**Colorado Springs Airport Advisory Commission Meeting
To Be Heard May 26, 2021
Land Use Review Item #13**

EL PASO COUNTY BUCKSLIP NUMBER(S)/FILE NUMBER(S): ADR213 <i>COMMERCIAL ADMINISTRATIVE RELIEF</i>	PARCEL #(S): 5407202035
DESCRIPTION: <p>Request by YOW Architects, PC on behalf of Blazer Electric Supply Company for approval of an administrative relief for the number of parking spaces. Due to a 6,500 square foot addition, 75 parking spaces are available instead of the required 80 spaces. The property is zoned I-2/CAD-O (Limited Industrial with Commercial Airport Overlay District) and consists of 4.16 acres. The property is located east of Powers Boulevard and south of Omaha Boulevard.</p>	
CONSTRUCTION/ALTERATION OF MORE THAN 1 200 FEET ABOVE GROUND LEVEL? No	DISTANCE/DIRECTION FROM COS: 2 miles north of Rwy 17R
TOTAL STRUCTURE HEIGHT AT THE ESTIMATED HIGHEST POINT: 45 feet above ground level; 6,355 feet above mean sea level	COMMERCIAL AIRPORT OVERLAY SUBZONES PENETRATED: Accident Potential Zone 2 (APZ-2)

17 SITE PLAN

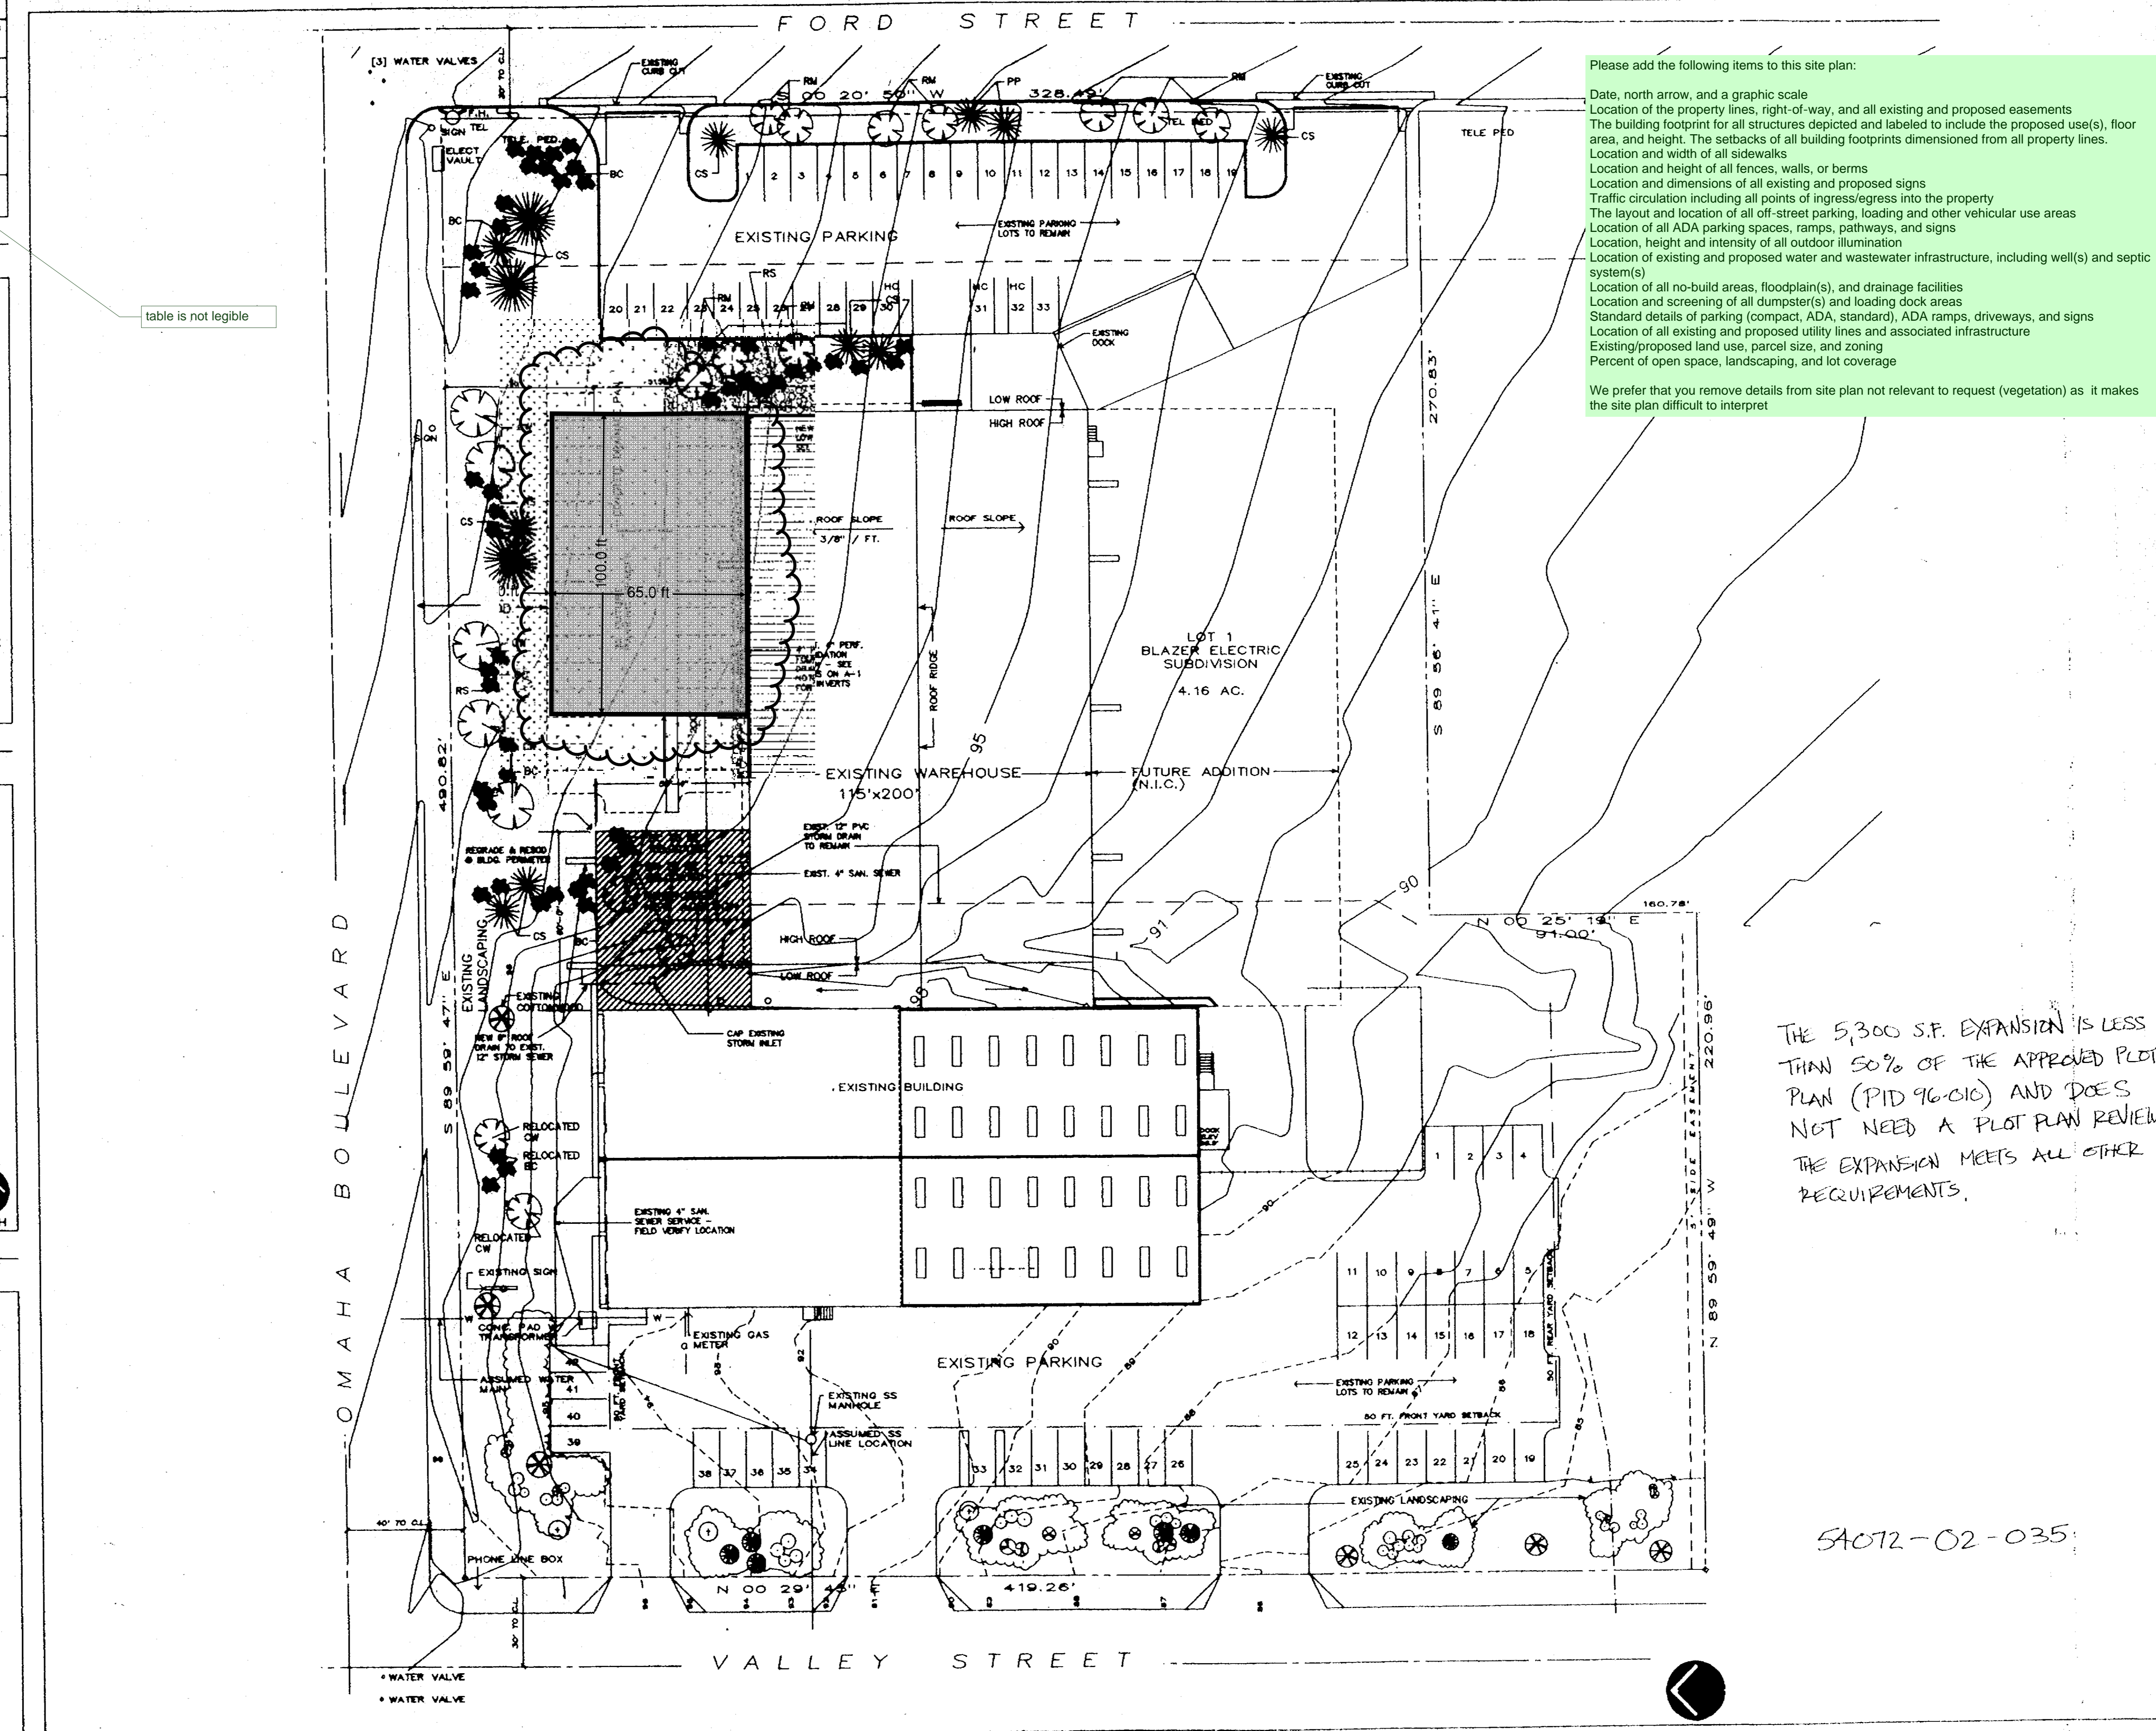
- **Avigation Easement:** An avigation easement was filed in 1973 in Book 2580 at Page 371; easement not shown on submittal document.
- **APZ-2:** The proposed development is within the Accident Potential Zone 2 (APZ-2) subzone of the Commercial Airport Overlay District, as adopted by El Paso County. The proposed use associated with this development appears to be permissible in the APZ-2 subzone.
- **FAA Form 7460-1:** Based on elevation data and distance to runway, the applicant will need to file Federal Aviation Administration (FAA) Form 7460-1 "Notice of Proposed Construction or Alteration" for any new vertical development at this site, including temporary construction equipment, and provide FAA documentation to the Airport before the commencement of construction activities; FAA's website (<https://oeaaa.faa.gov/oeaaa/external/portal.jsp>).
